### **Peaceful Valley Adjustment, EXBL-17-001**

**Please accept the following comments from El Paso County Public Health regarding the project referenced above:**

AS ADJUSTED

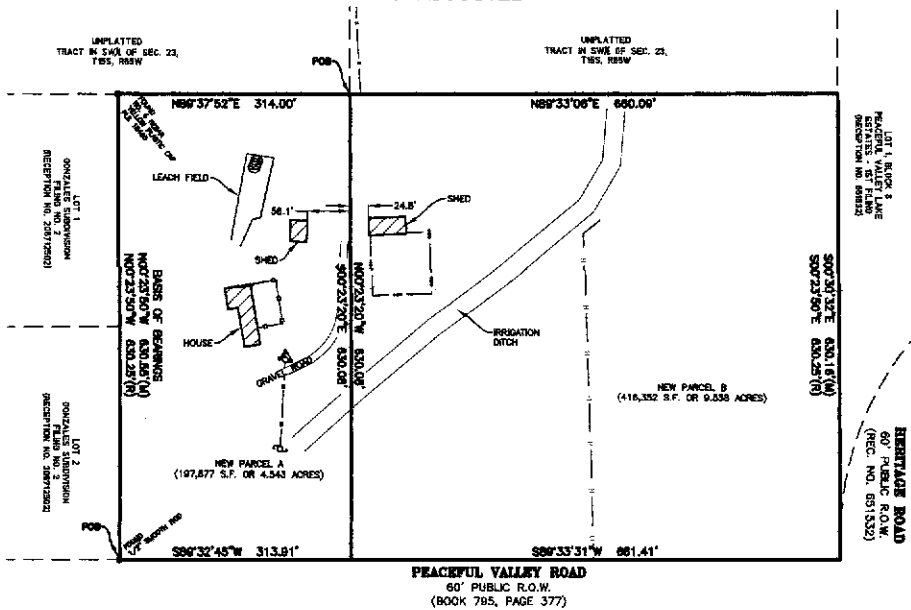
- **Parcel 5523002013 addressed as 10150 Peaceful Valley Road has a permitted and approved on-site wastewater treatment system (OWTS) installed. The soil treatment area was approved in 1972 and a new septic tank was permitted and installed on 21Oct2016.**
- **Based on the documents submitted for this project, and the records at El Paso County Public Health, it is apparent that the existing OWTS will meet all required installation setbacks when the boundaries are adjusted. Please contact El Paso County Public Health if there are any questions regarding the location of any of the OWTS components.**
- **Note: The soil treatment area must be 10' minimum from the new property line.**
